re: Geotechnical Review – Tree Planting Restrictions & Setbacks
Proposed Residential Development – Wateridge Block 105
Mikinak Road & Vedette Way – Ottawa, Ontario

date: October 30 2025

file: PG7353-MEMO.01

L1.0

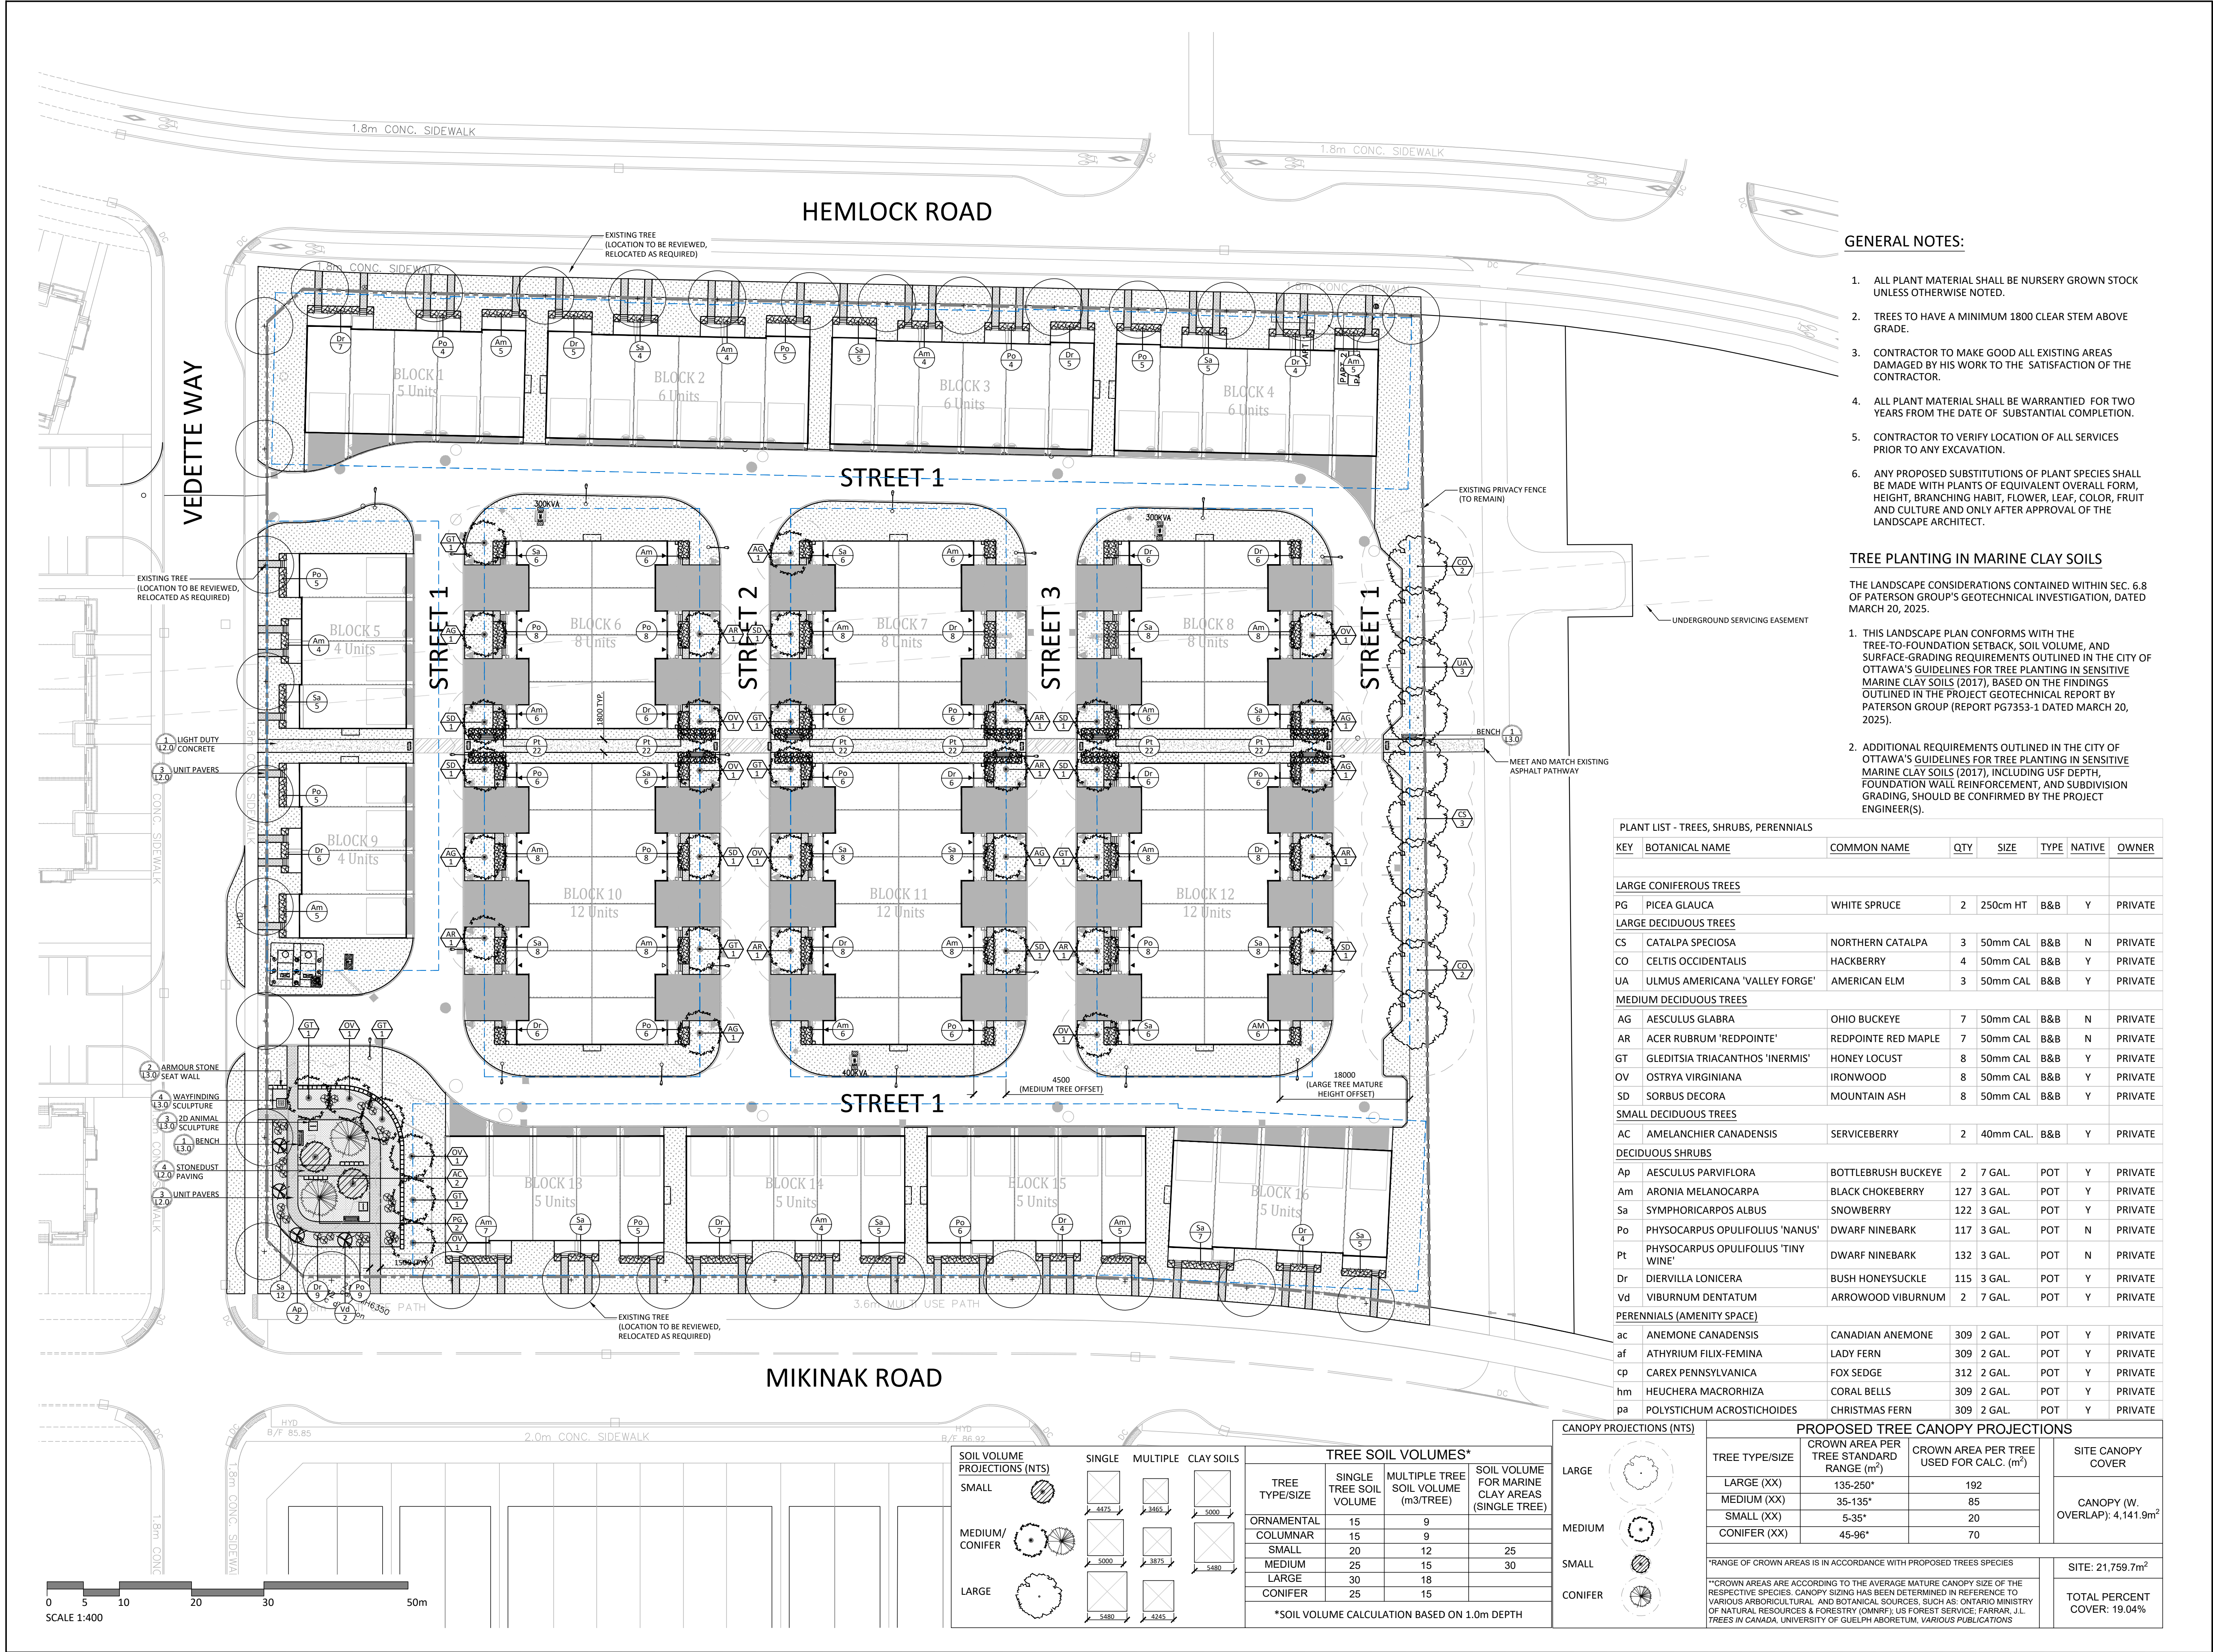
- ☐ Block 105, 615 Mikinak Road, Wateridge Village – Job No. 25-066 - Landscape Plane – Sheet No. L1.0 – Revision 5 dated October 21, 2025, prepared by NAK design strategies.

During the geotechnical investigation, Paterson completed laboratory testing in accordance with City of Ottawa Tree Planting in Sensitive Marine Clay Soils (2017) Guidelines. Based on the results of this testing, the silty clay at the subject site is considered to be a low to medium sensitivity clay.

As such, a tree planting setback limit of 4.5 m from foundation walls is applicable for small (mature tree height up to 7.5m) and medium size trees (mature tree height 7.5 m to 14 m) provided that, among other conditions, the underside of footing (USF) of the adjacent building(s) is 2.1 m or greater below the finished grade.

Where the proposed building footings are located less than 2.1 m below finished grade, Paterson recommends one of the following be done:

- ☐ Subexcavate the existing fill material and/or native clay soil to a depth of 2.1 m below the proposed finished grade and backfill up to USF using Ontario Provincial Standard Specifications (OPSS) Granular A or B Type II. The material should be placed in maximum 300 mm thick lifts and compacted to at least 98% of its standard Proctor maximum dry density (SPMDD).
- ☐ The engineered fill pads should extend 150 mm beyond the edge of the building footings, with a minimum 300 mm thickness.

- ☐ Extend lean concrete from the USF to a depth of 2.1 m below the proposed finished grade. The lean mix concrete should consist of a minimum 17 MPa 28-day compressive strength concrete and extend at least 150 mm wider than all sides of the footing (strip and pad footings) at the base of the excavation.
